EPC STORMWATER REVIEW COMMENTS
 IN ORANGE BOXES WITH BLACK TEXT

EL PASO COUNTY GRADING AND EROSION CONTROL PLAN CHECKLIST

EPC Project Number: **PPR2346**

SHEET #:
A-201

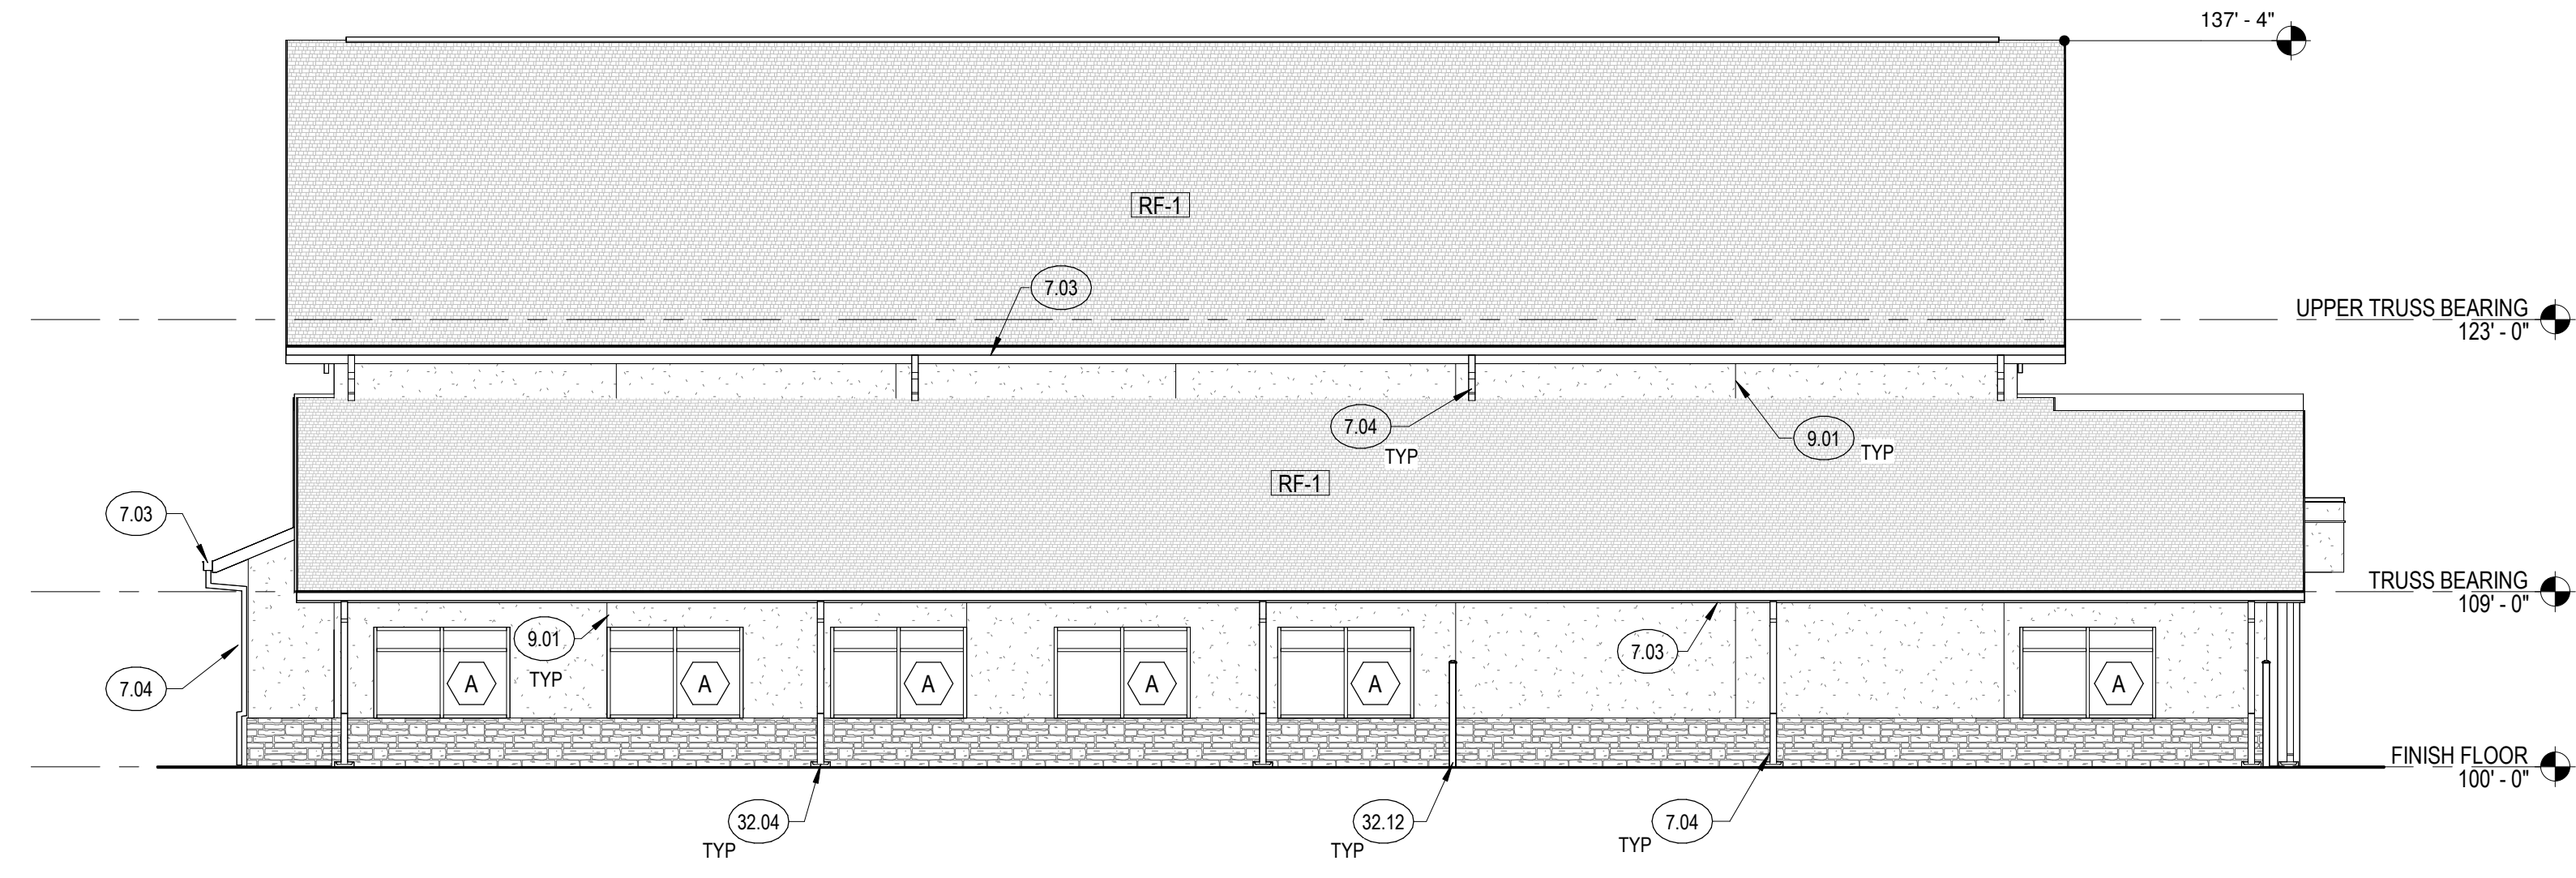
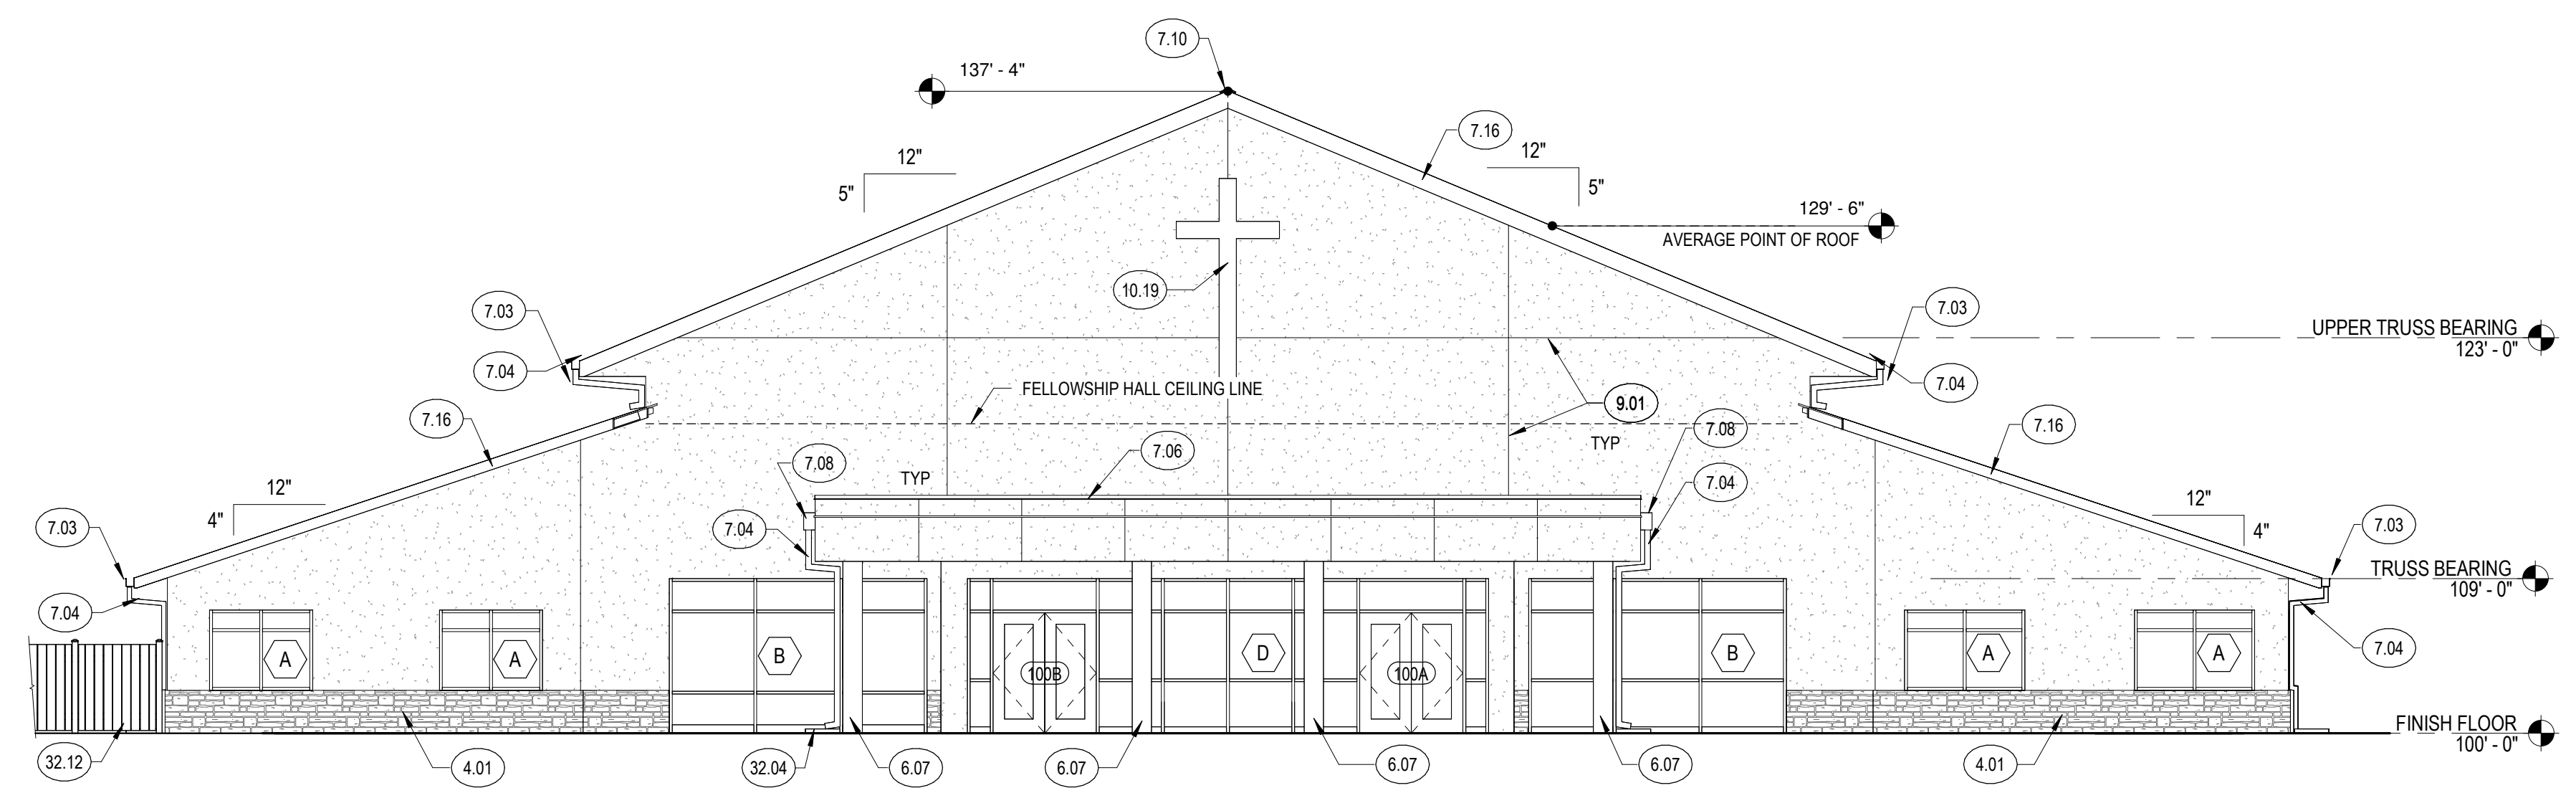
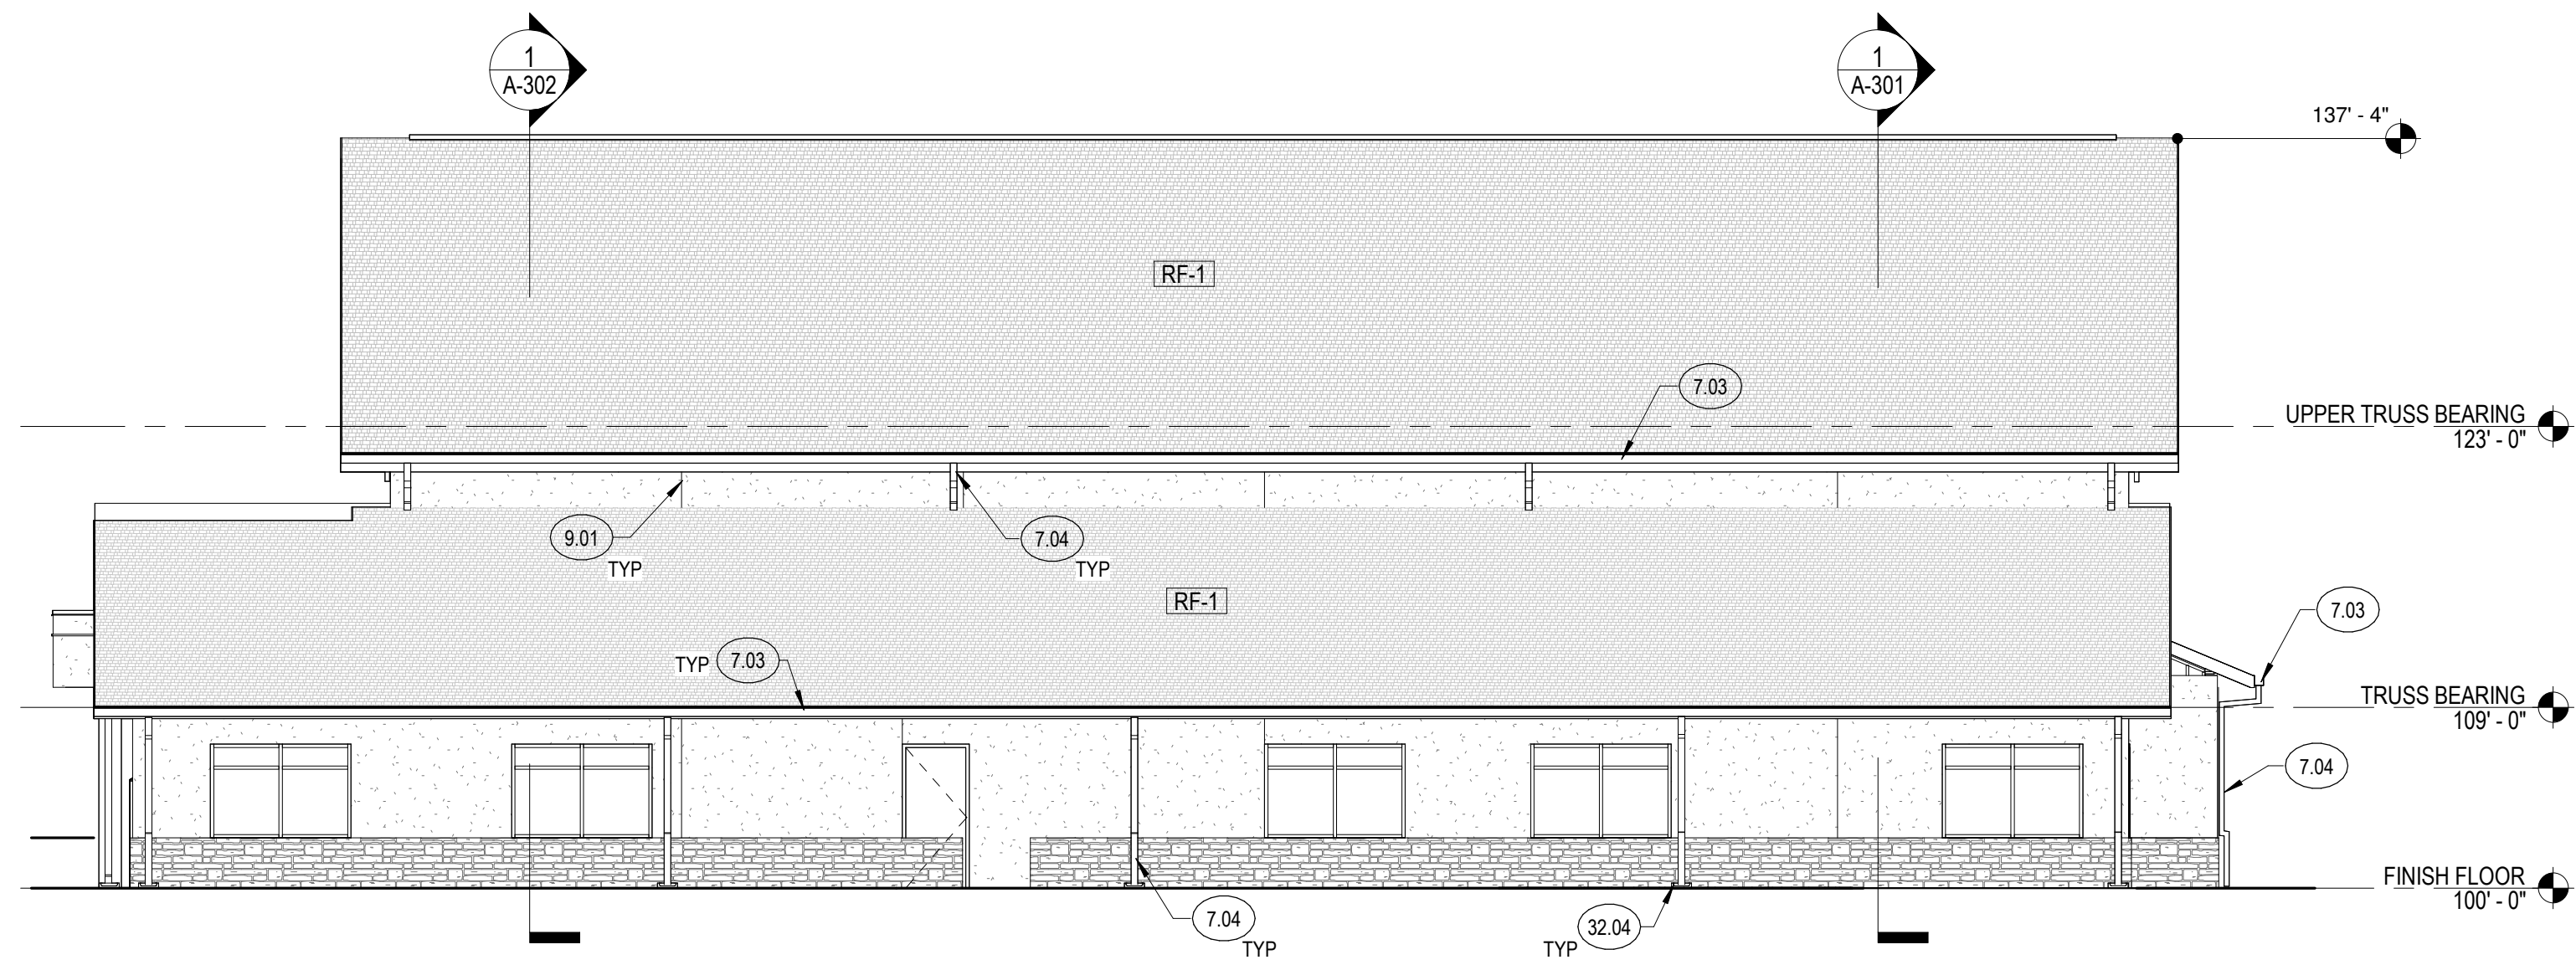
Clearly label retaining walls on GEC Plan
